From: Paul Troop <pault@gclaw.co.uk>
Sent: 13 September 2024 15:53
To: Planning
Cc: Bbosa, Rashid - Oxfordshire County Council; Catherine Hickman
Subject: 24/02058/F Comments

I write as secretary of the Bicester Bike Users' Group. We have a particular concern that the current design of the development is very car dependent. The current design closes off the opportunities for visitors, residents, or employees to travel between the facility or the town centre or Langford Park by wheelchair, mobility scooter, foot, or cycle.

TITLE
 PROPOSED SITE PLAN

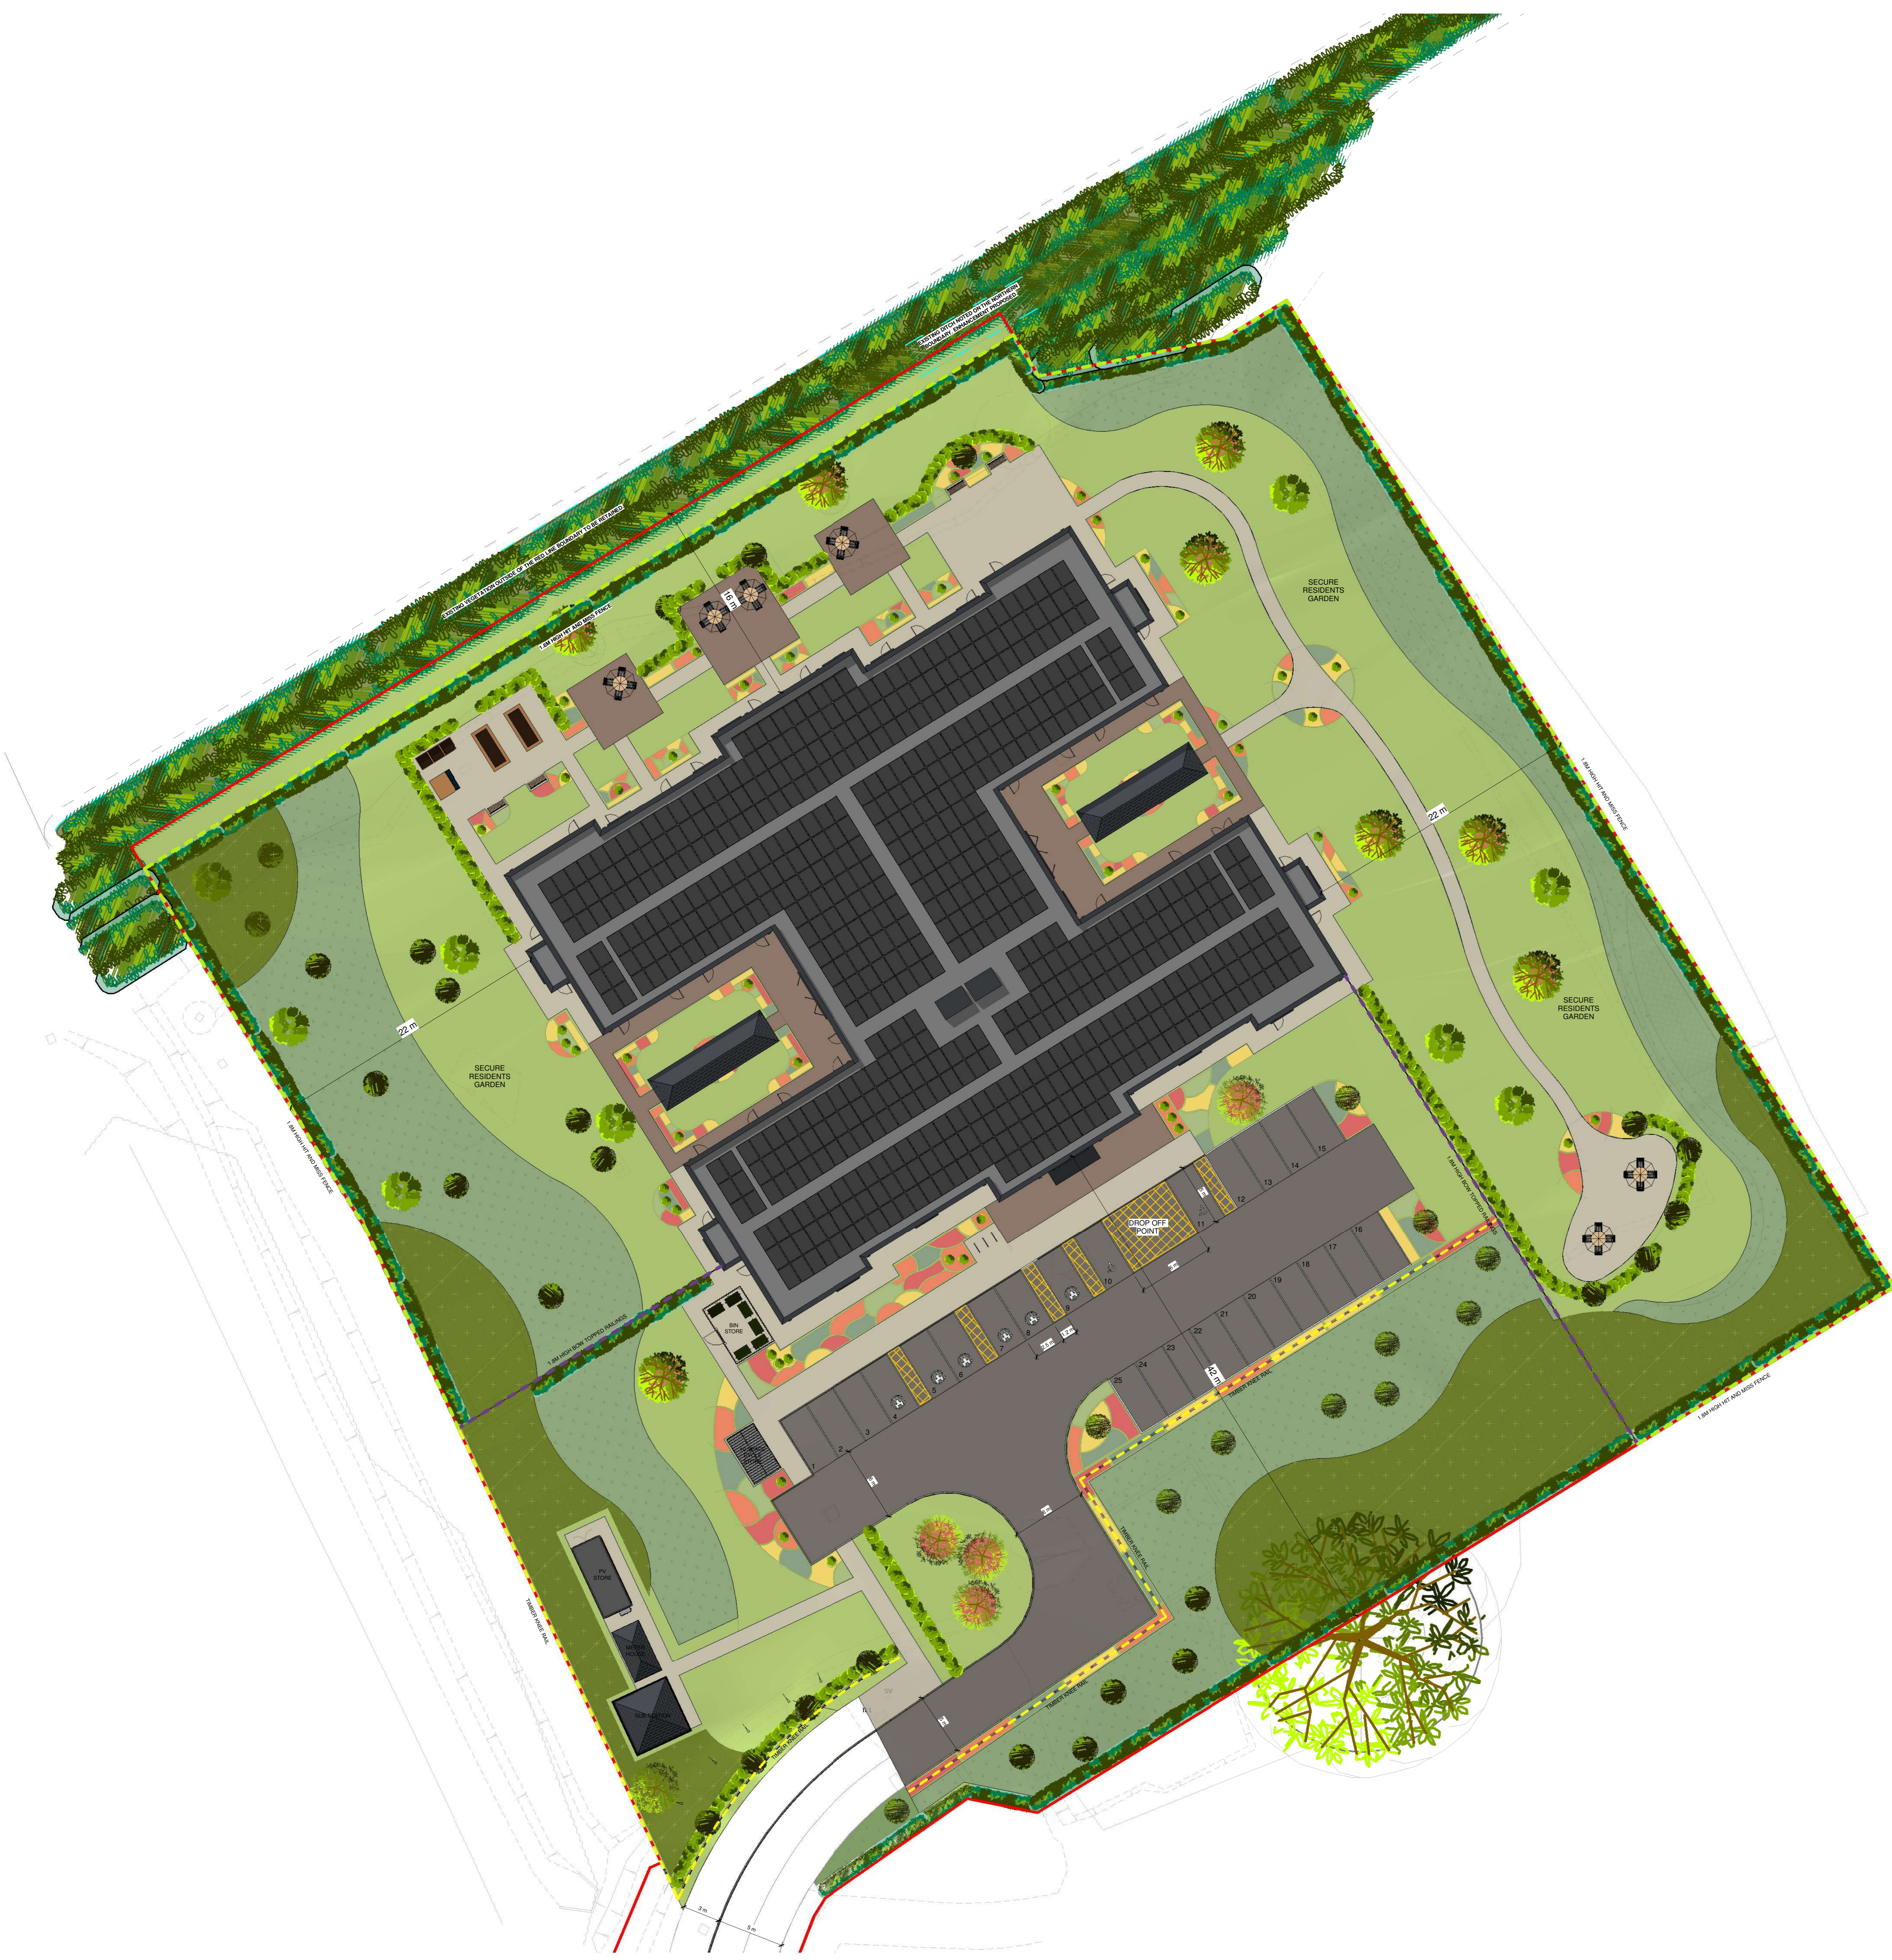
The issue is that the shortest and quickest route for non-motorised means of transport is from the existing means of access to the former Rodney House social centre site is via the northeastern corner. This connects via land due for development to the A41 underpass, to the London Road, and to the Langford Fields park via a new parallel crossing over the London Road currently in development with Active Travel England funds. This route has been earmarked to be preserved in the Local Cycling and Walking Infrastructure Plan.

However, as currently designed, there is no link from the site to this route. Instead, non-motorised users are expected to take a very circuitous route all the way around the site, adding at least a kilometer to the route (considering both directions) and precluding non-motorised options.

It is strongly advised that a non-motorised route is preserved along the northwestern boundary of the site to enable this essential link to be preserved and connected with pedestrian and cycle routes on the Graven Hill masterplan:

This would also have another significant benefit to the site in that it would enable residents to access the community centre and recreation fields to the west. In addition, it would have the collateral benefit of preserving a foot and cycle path between the community centre and recreation fields and Bicester town centre.
